Ribble Valley Borough Council
Housing & Development Control

Your ref: 3/2023/0627
Our ref: D3.2023.0627
Date: 1st September 2023

Application no: **3/2023/0627**

Proposal: **Proposed demolition of existing rear car port and kitchen and construction of singlestorey extension to rear with rooflights. Two rooflights to be installed in loft conversion. Resubmission of 3/2023/0235.**

6842-001 REV

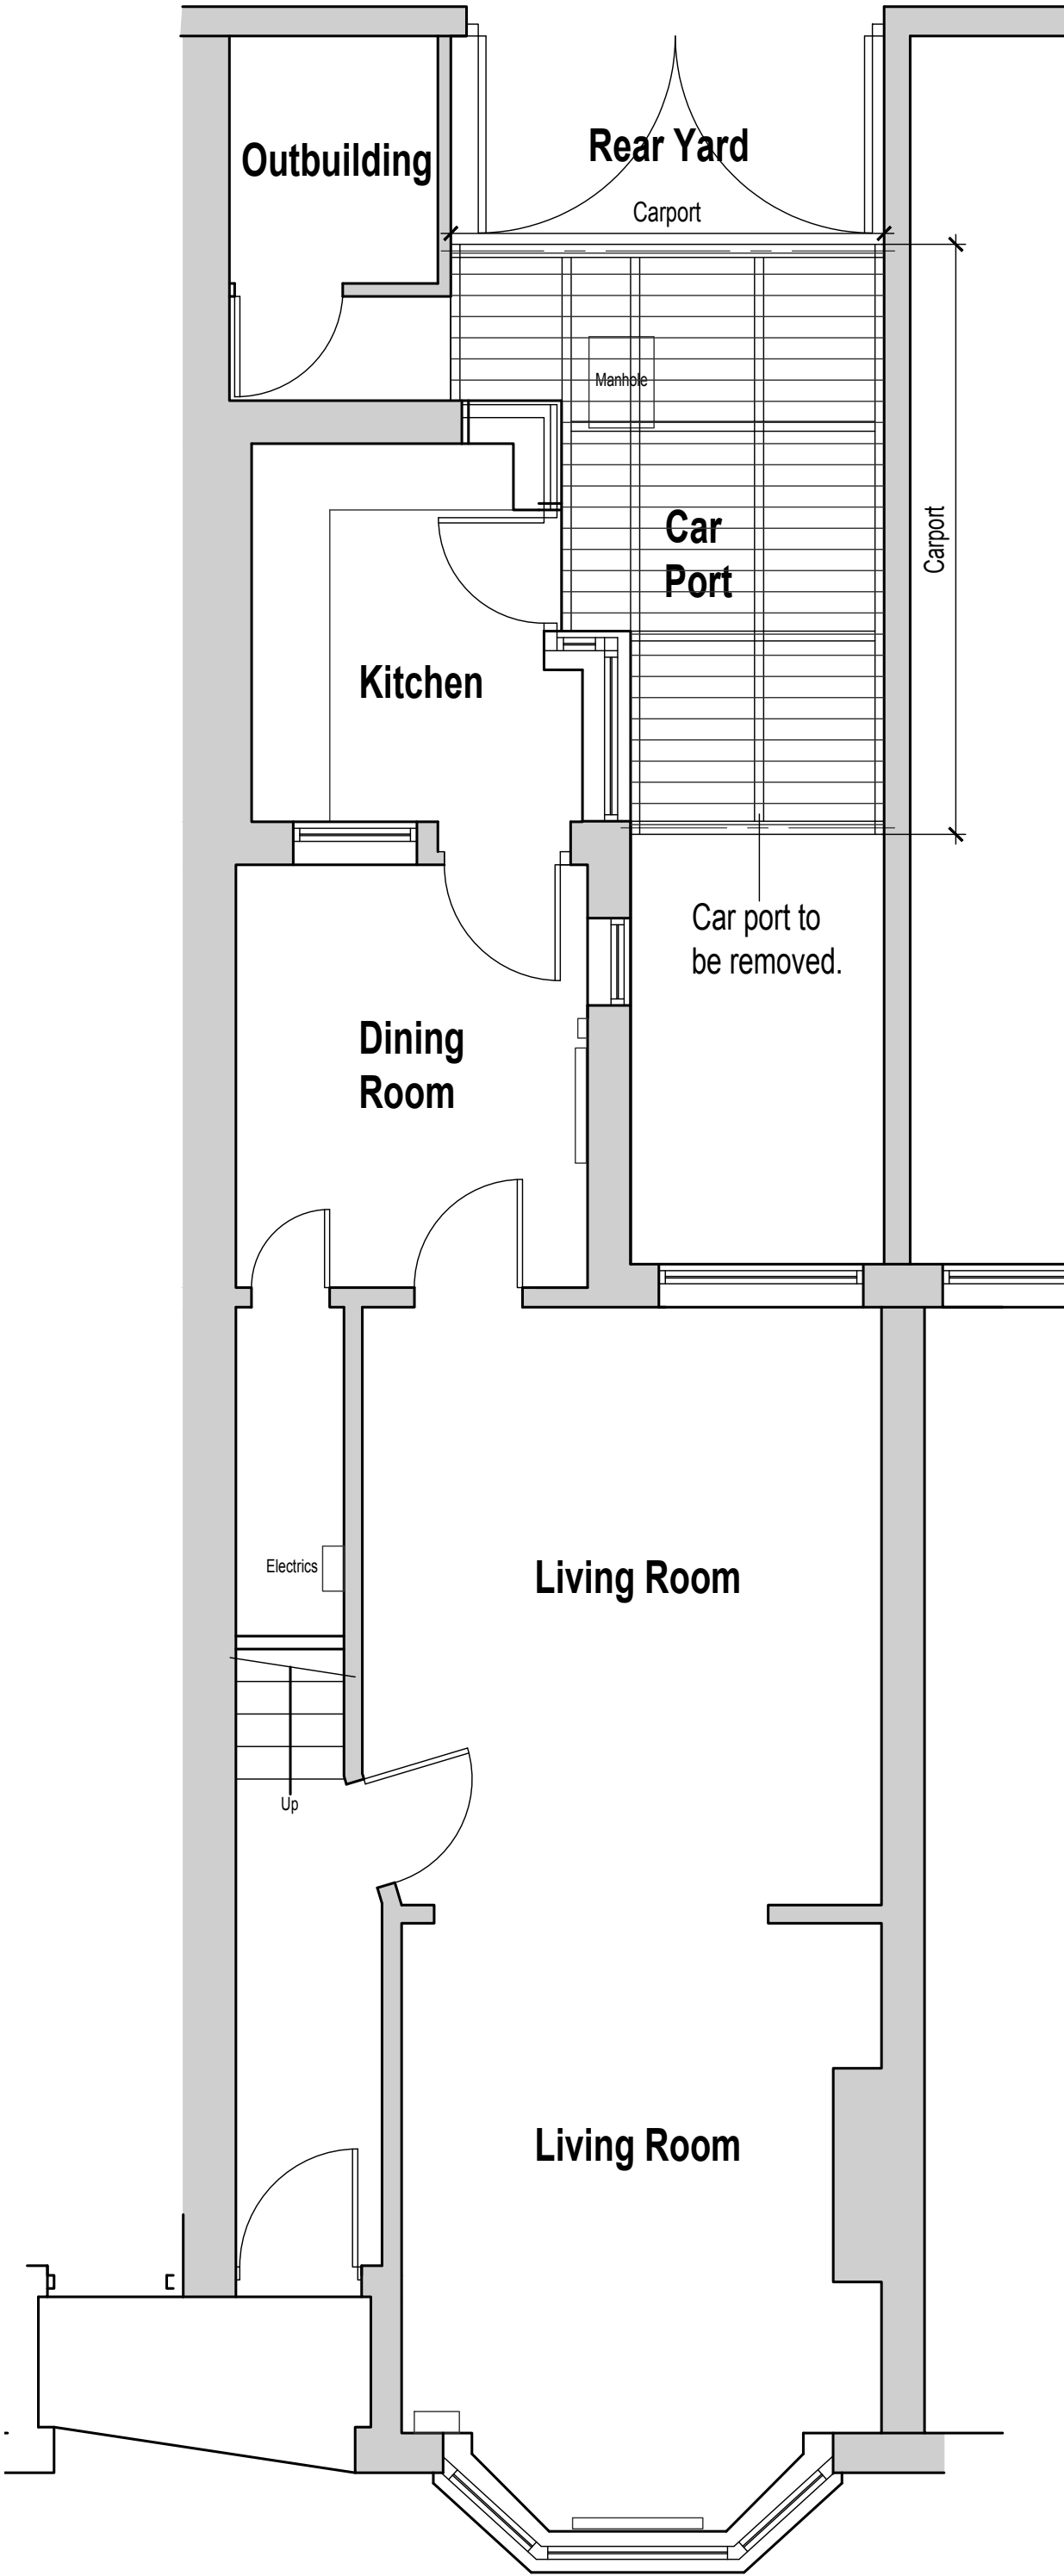
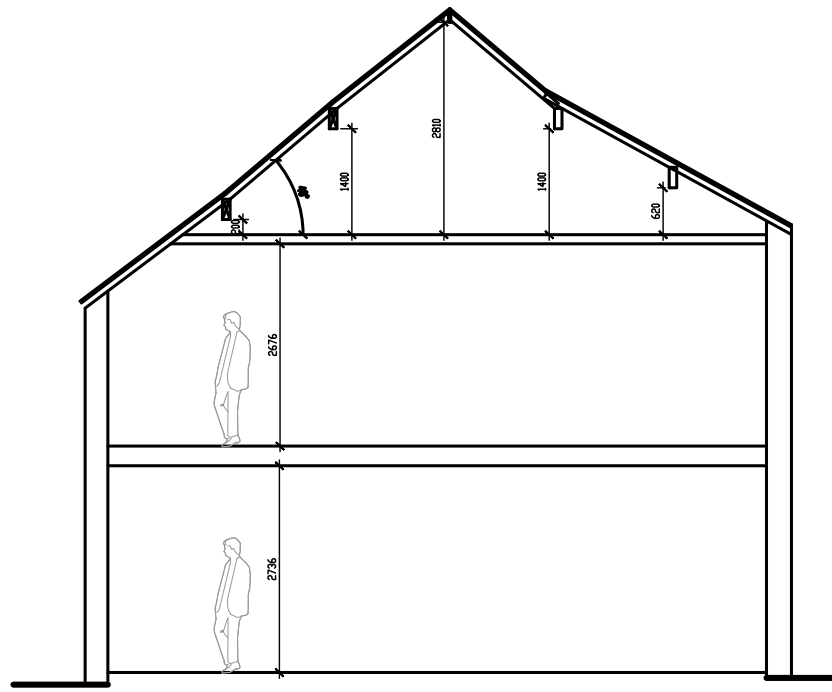
Despite this, the LHA will accept the shortfall in parking at the site. This is because while the existing dwelling does have access to a car port to the rear of the site, the car ports internal dimensions as shown on SPA drawing number 6842-001 titled " Existing Floor Plans, Elevations and Location Plan", does not comply with the LHAs guidance. Therefore, it is unlikely that a car will be able to use the area in any case and so the site already has a shortfall of 2 spaces. Adding another car parking space to the shortfall is unlikely to be at the detriment to highway safety, especially when the occupants are already aware of their parking situation and so would any future occupants, before occupying the property.
